Application no: 22/02780/DISC

Location: Bicester Heritage, Buckingham Road, Bicester

Lead Local Flood Authority

Date: 31/01/2023

Title: Drainage Layout
Sheet 1 of 3

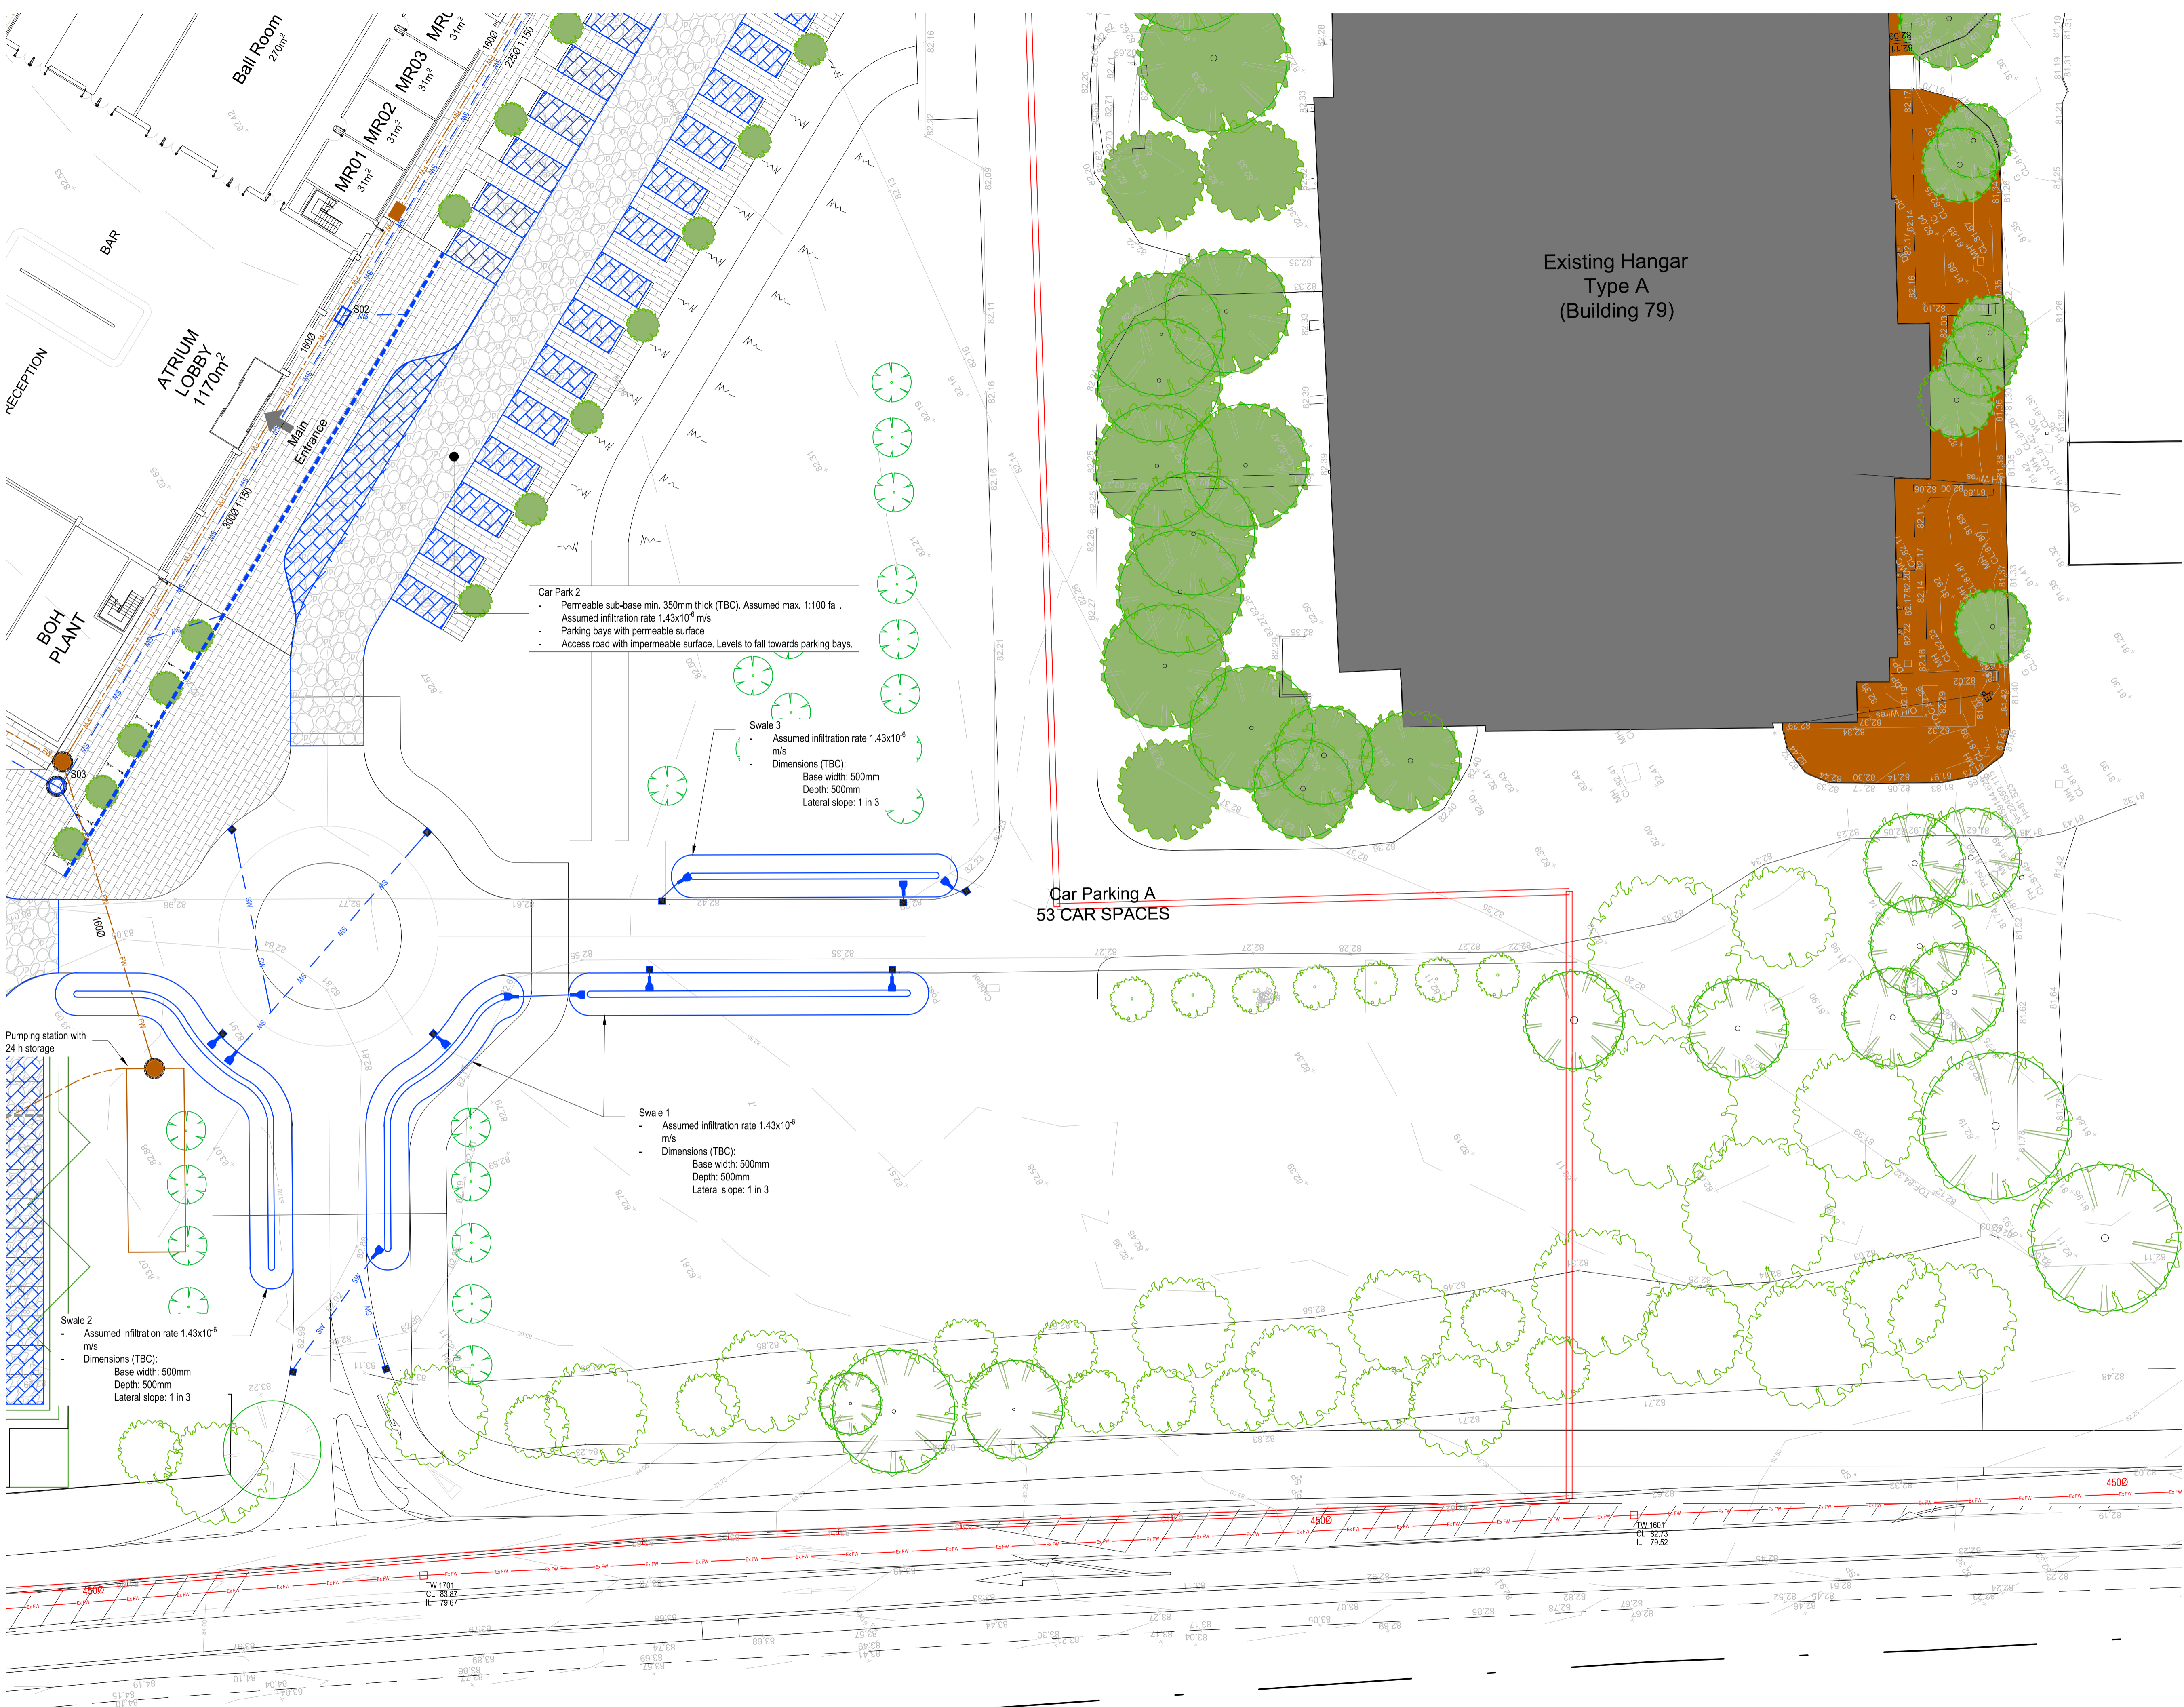
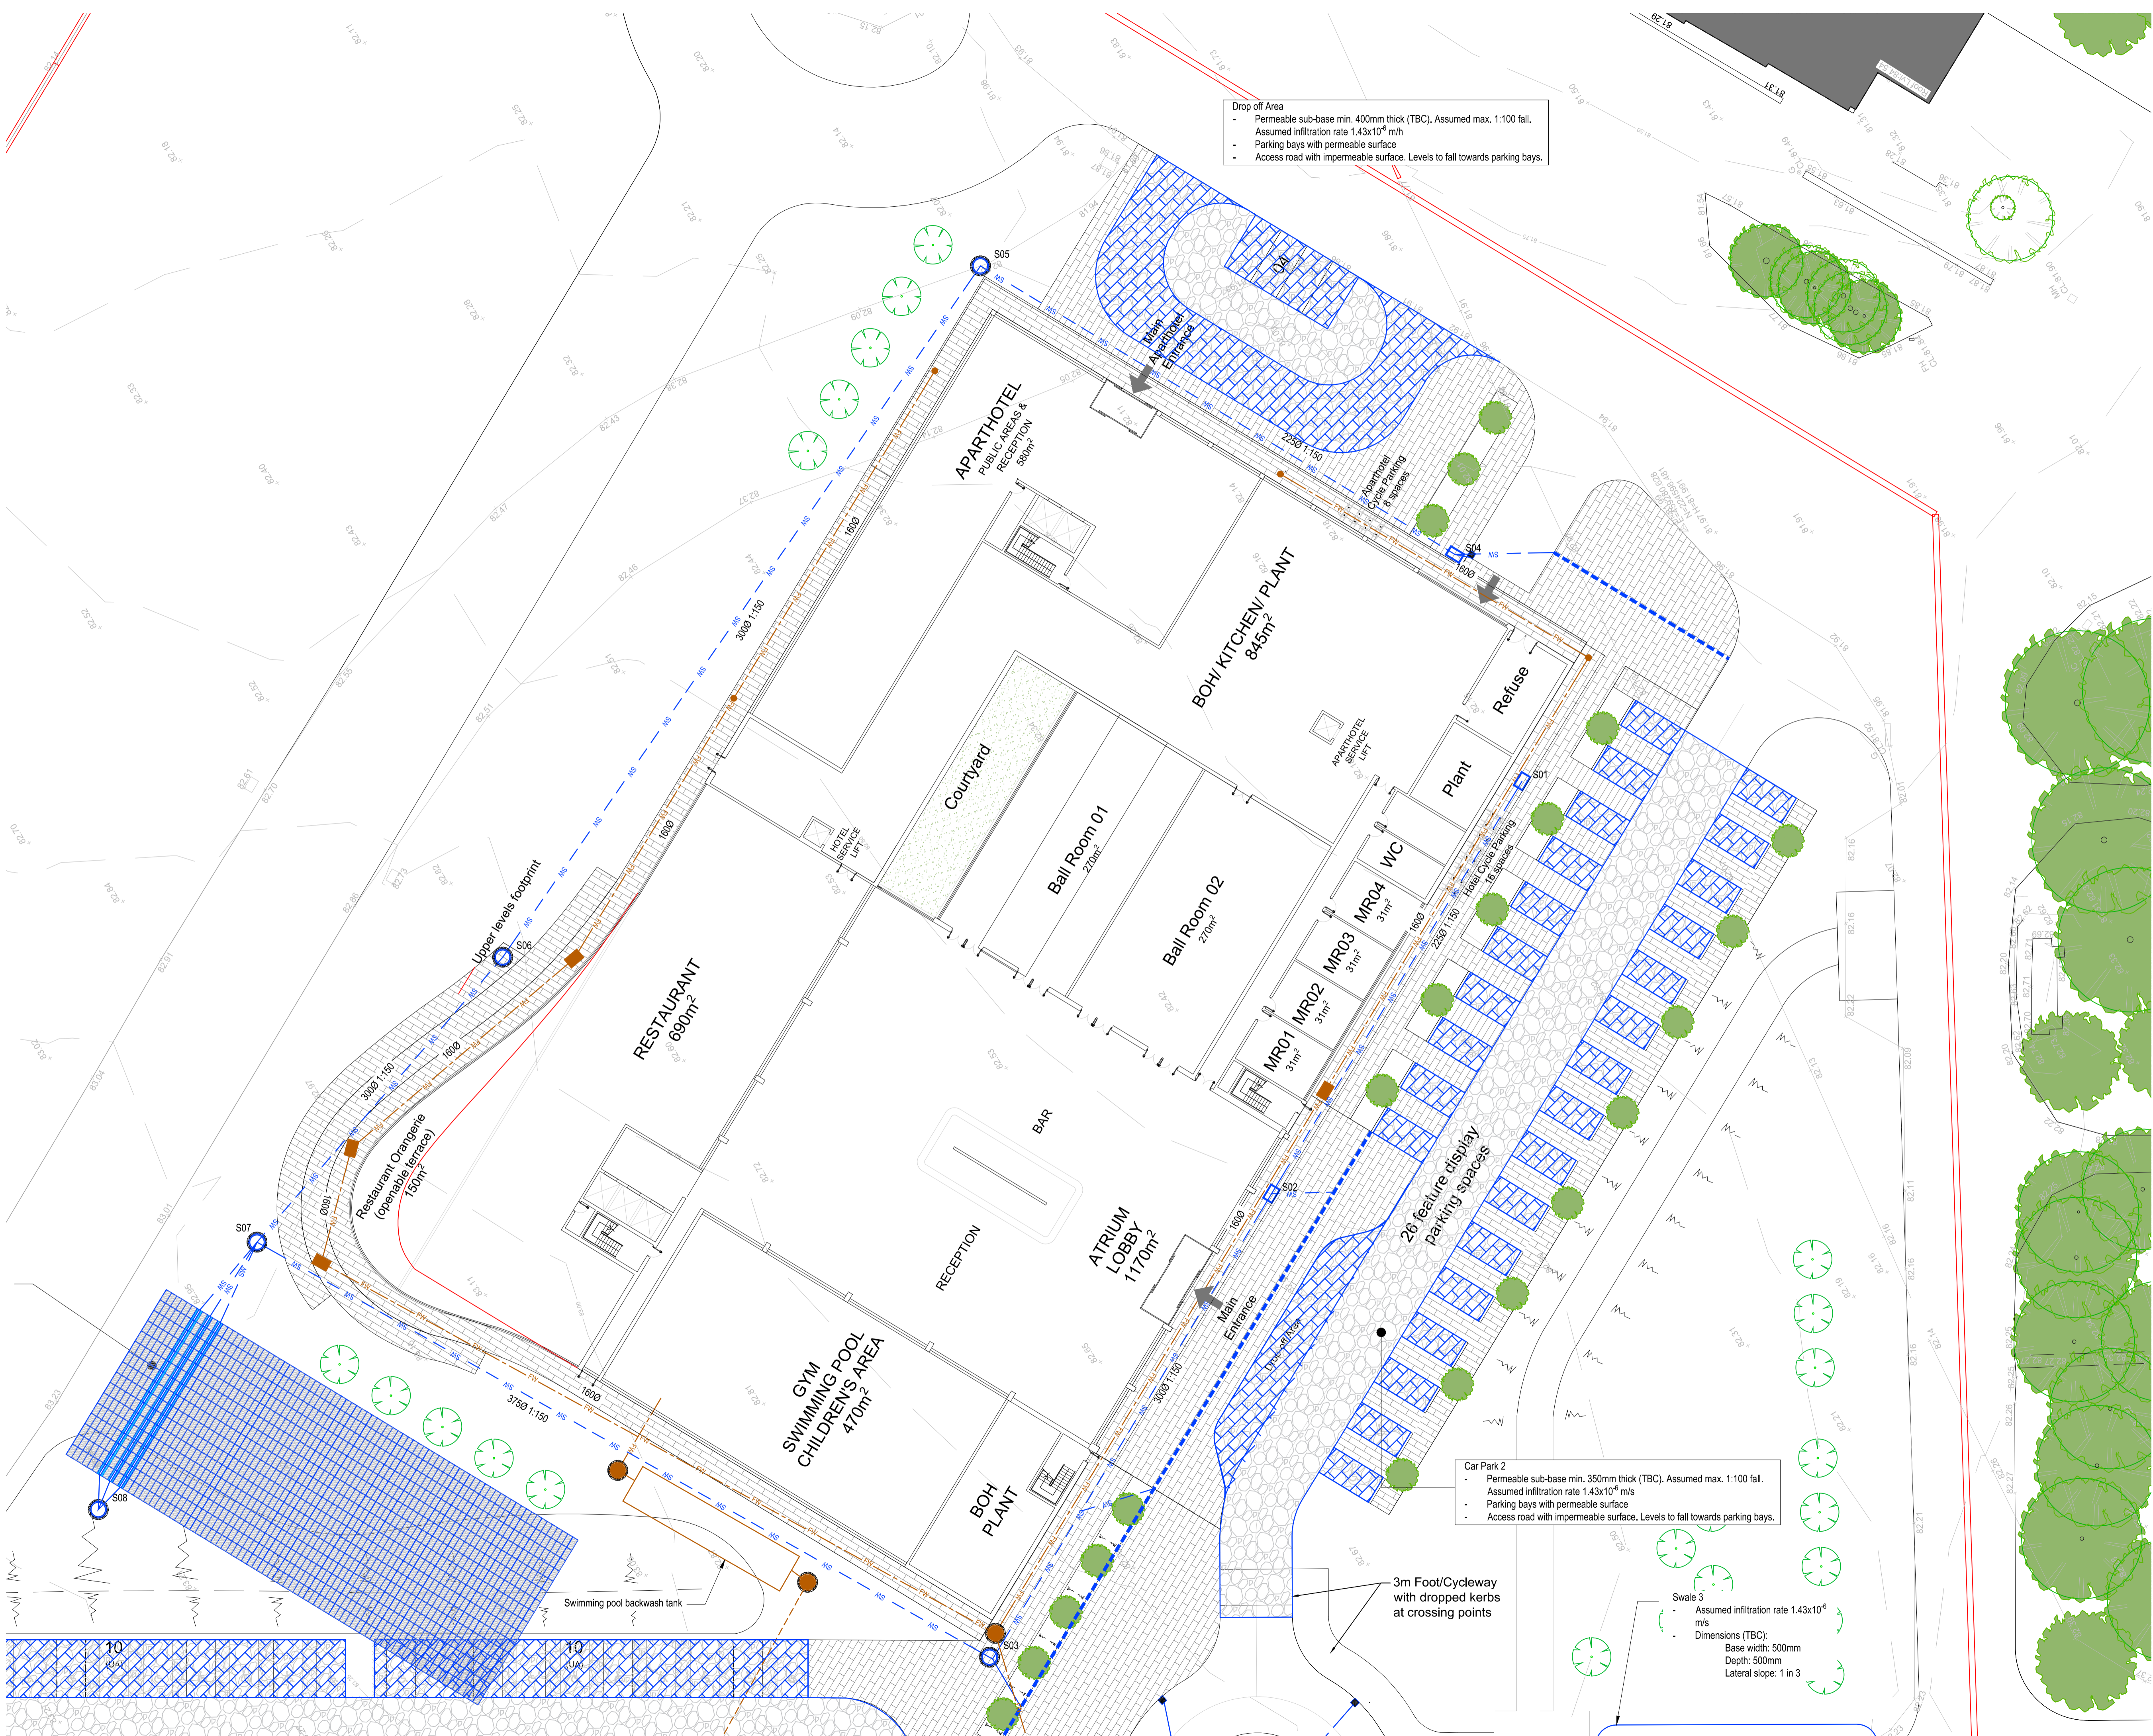
Provide discharge rates on the drainage plan for each proposed SuDS. The plan states discharge rates to be confirmed, at this stage all drainage drawings should be detailed and include the final design in order to discharge the condition.

Provide surface water catchment plan which clearly indicates the extent of the impermeable areas and to which SuDS feature it will drain to, catchment areas for the external areas are still not given.

Clarify the Key on the drainage plan, is the hard standing areas in grey permeable paving or will this drain towards the permeable paving in blue. This is still very confusing the key does not reflect exactly what is on plan.

The drainage plan is not detailed, show the RWP pipes and how its connected to the SuDS.

PROPOSED Overland Flow Drawing

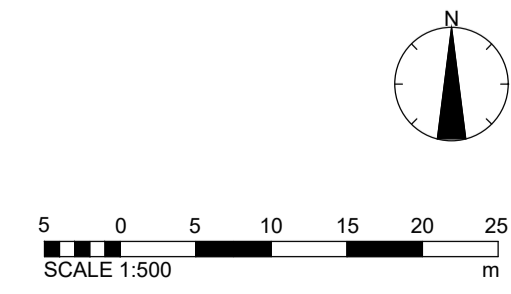
Not provided. Provide flood exceedance plan showing that all surface water will be kept away from structures and within the site boundary. Include levels and flood

arrows to demonstrate this.
